Appeal Decision

Appeal Ref: APP/R4408/W/19/3222977

12-14 Eldon Street North, Barnsley S71 1LG

- The appeal is made under section 78 of the Town and Country Planning Act 1990 against a refusal to grant planning permission.
 - The appeal is made by Mr D Appleby against the decision of Barnsley Metropolitan Borough Council.
 - The application Ref 2018/0946, dated 24 July 2018, was refused by notice dated 20 September 2018.
 - The development proposed is a change of use from A1/B1 to Sui Generis Proposed 8 Bedroom House of Multiple Occupation.
-

Proposed Layouts

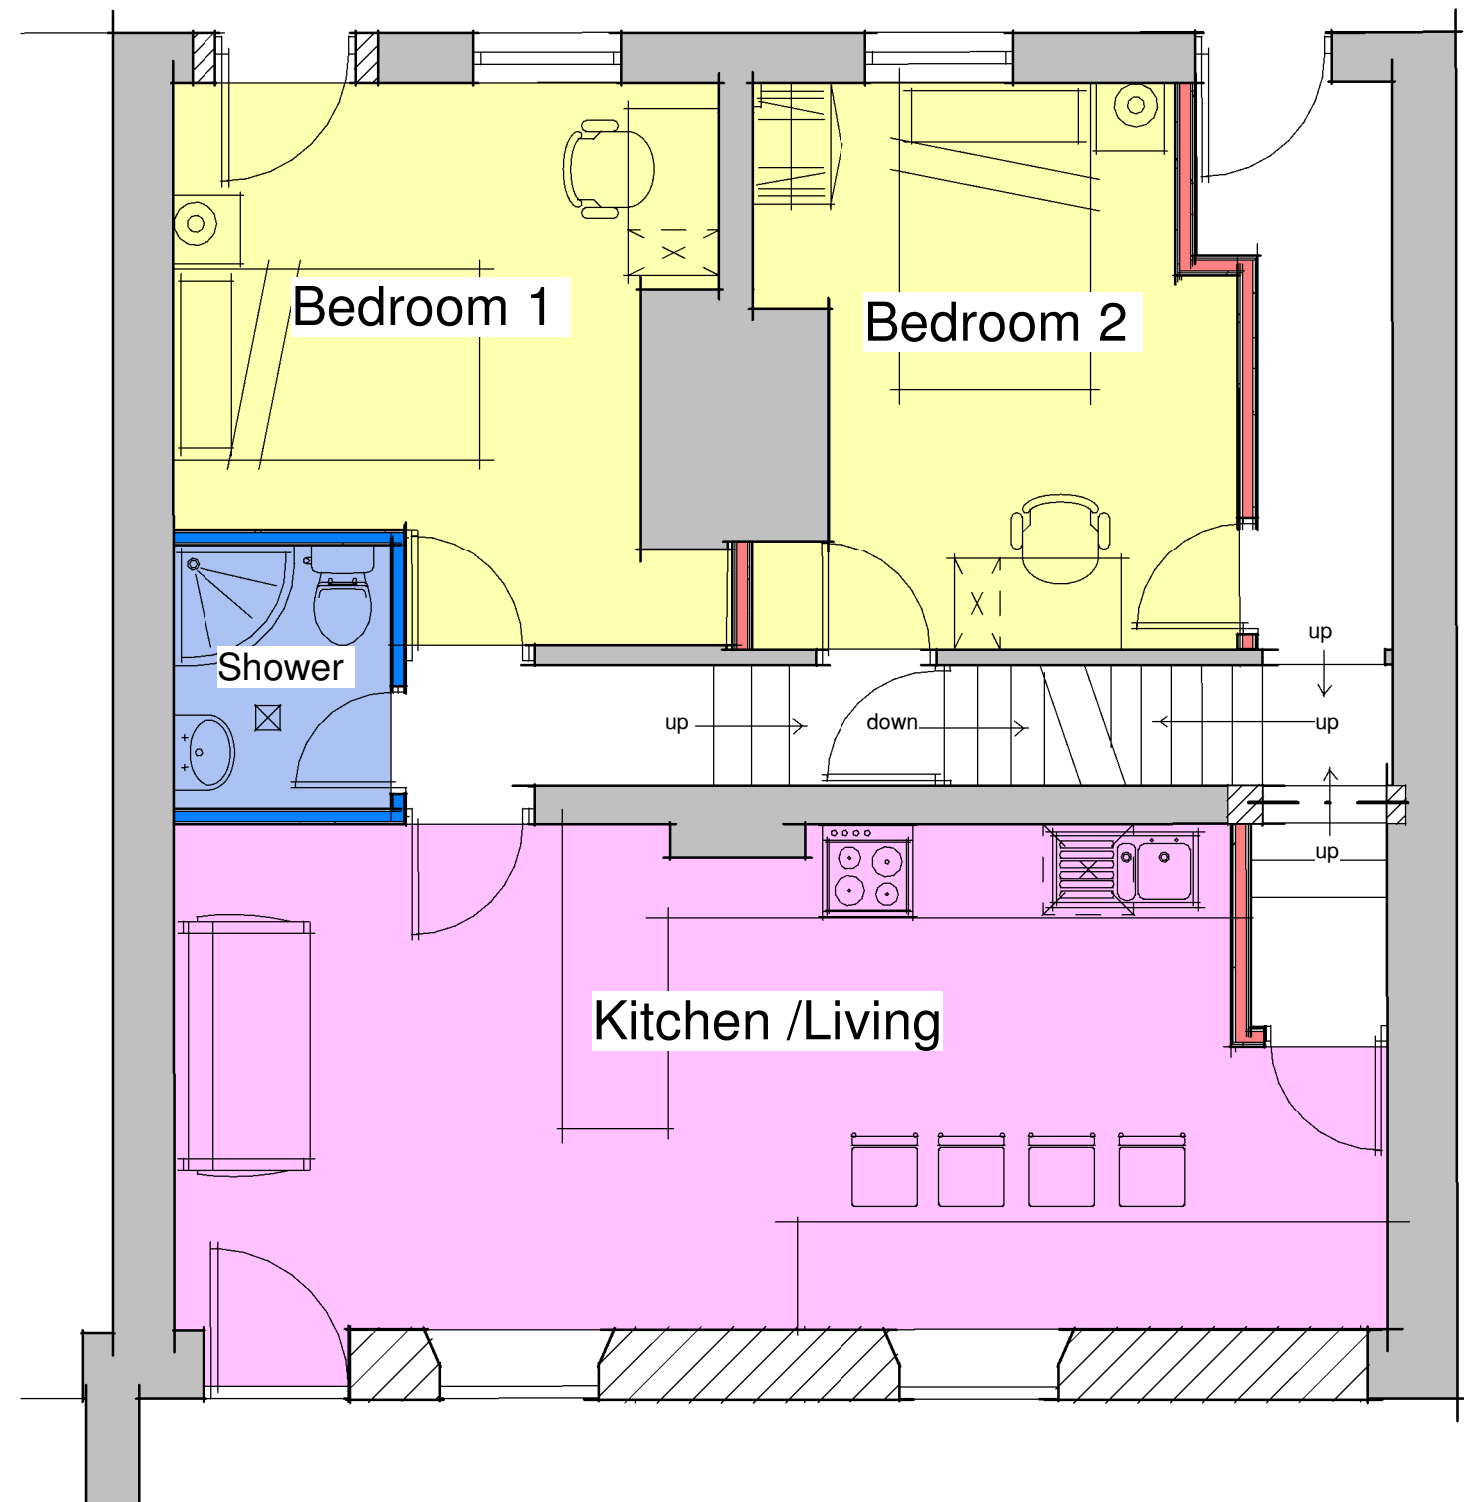
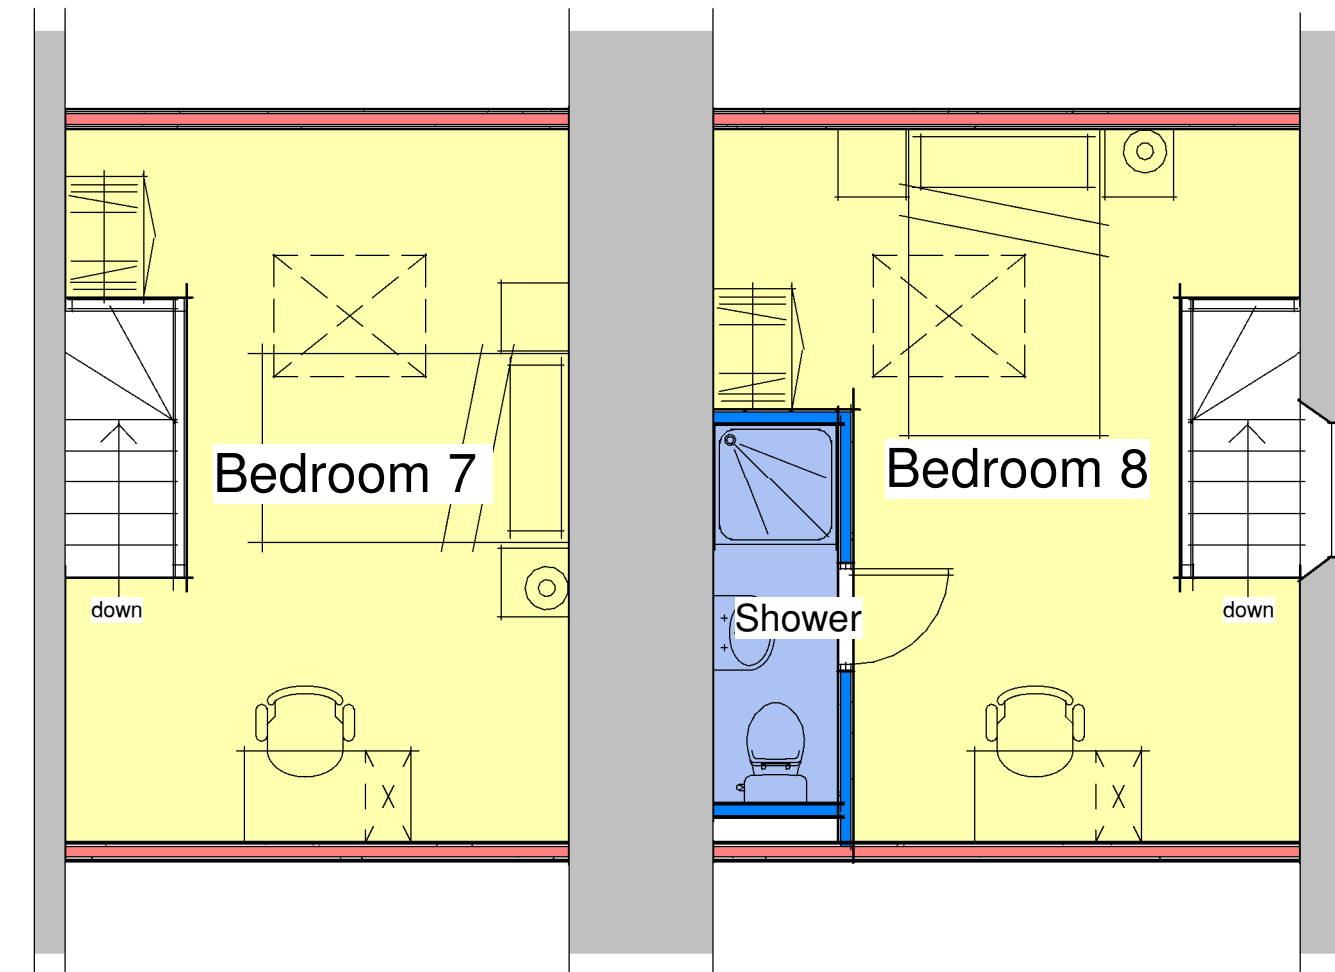
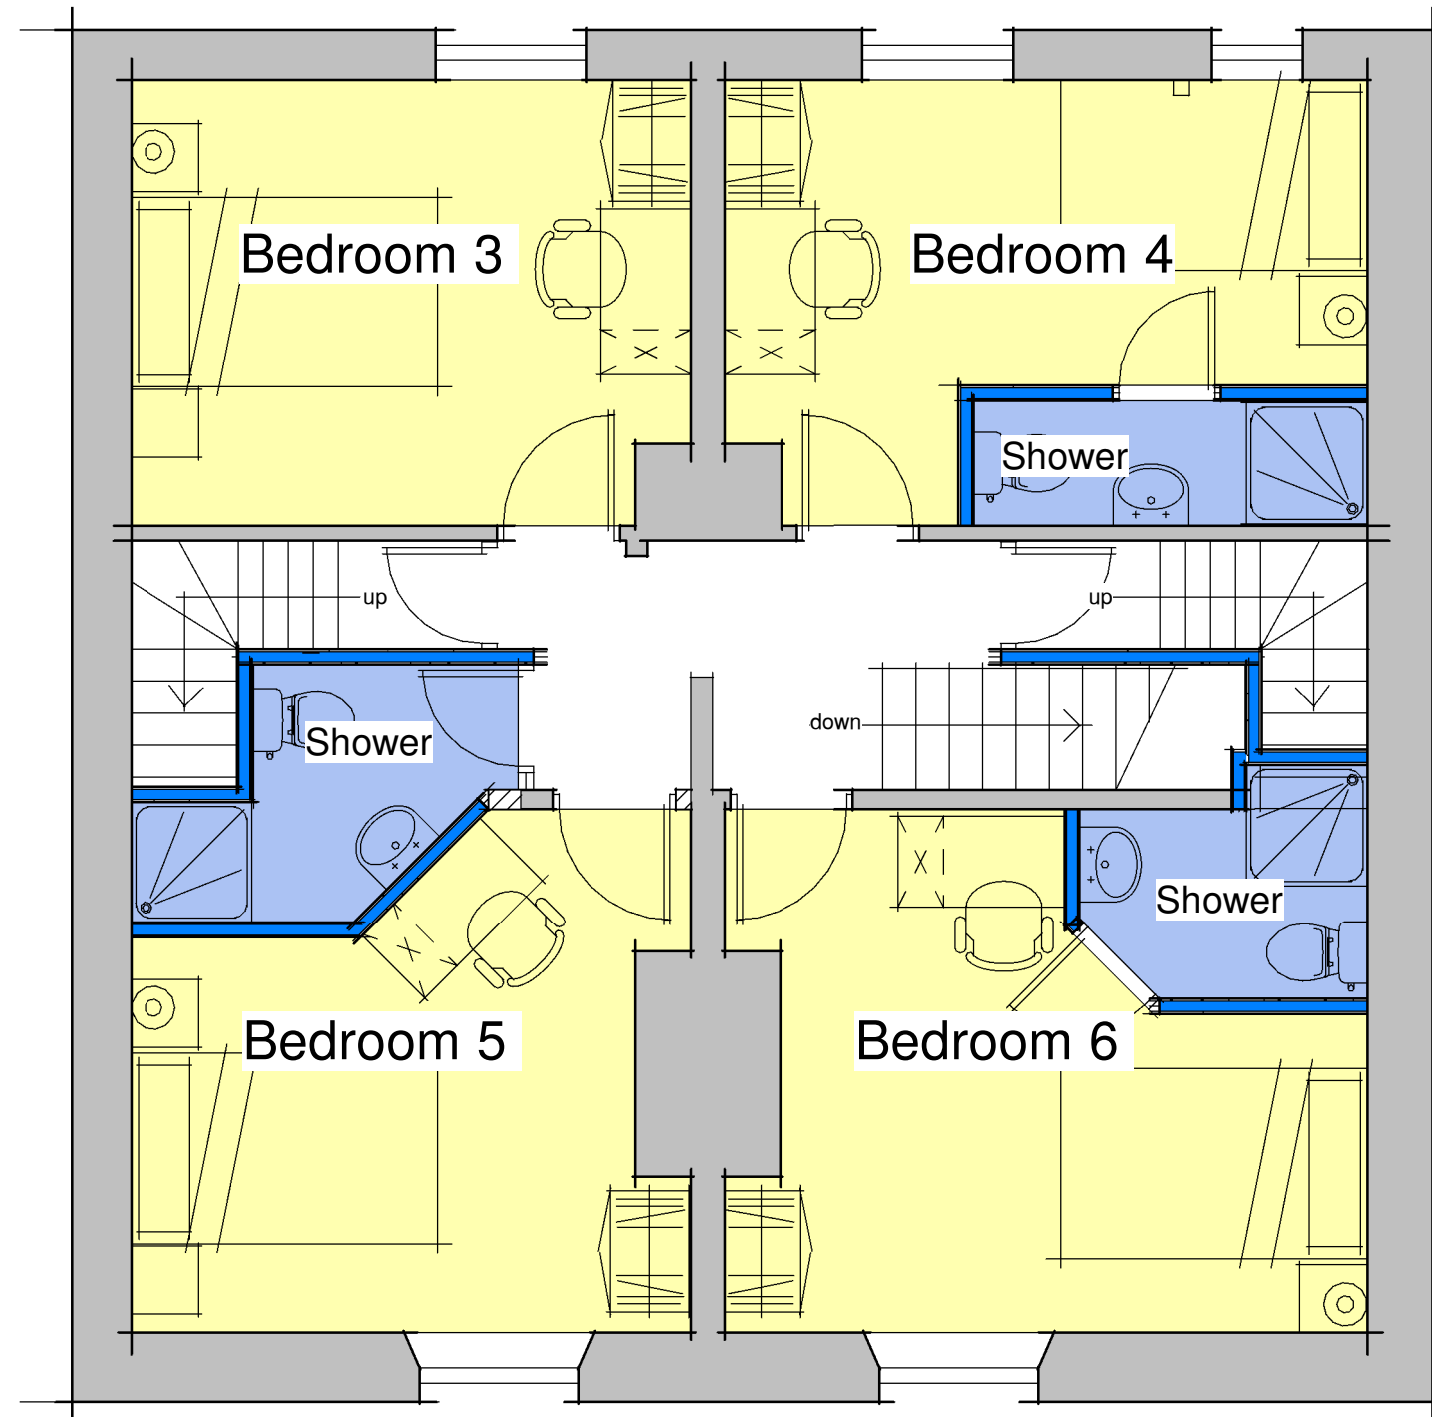
19. In this context, the SYRDG recommends that bathrooms should be 3.5m² minimum. Those within the HMO proposed would range between 1.6m² and 2.3m² falling significantly below the standard. For kitchen/dining/living areas,

the SYRDG recommends that it should be at least 30m² for a smaller 3 bed/4 person dwelling, applicable to a larger house also. The communal kitchen/living/dining area would be 25m², below the minimum standards. Furthermore, the kitchen layout indicates one hob, one sink and four chairs along a bar bench style seating/eating area whilst the living area would provide space for one sofa. I consider that this communal space would be inadequate to serve the needs of eight individuals, even taking into account that they may not always use the space at the same time.

21. Taken together and having regard to the SYRDG as a guide to achieving a good standard of accommodation, both the communal kitchen/living/dining area and the external garden/yard would, in my view, be limited for 8 occupants. The bathrooms would also be small, particularly as five of the occupants would have to share two of these shower/WC rooms. These factors combine to create a poor standard of accommodation.
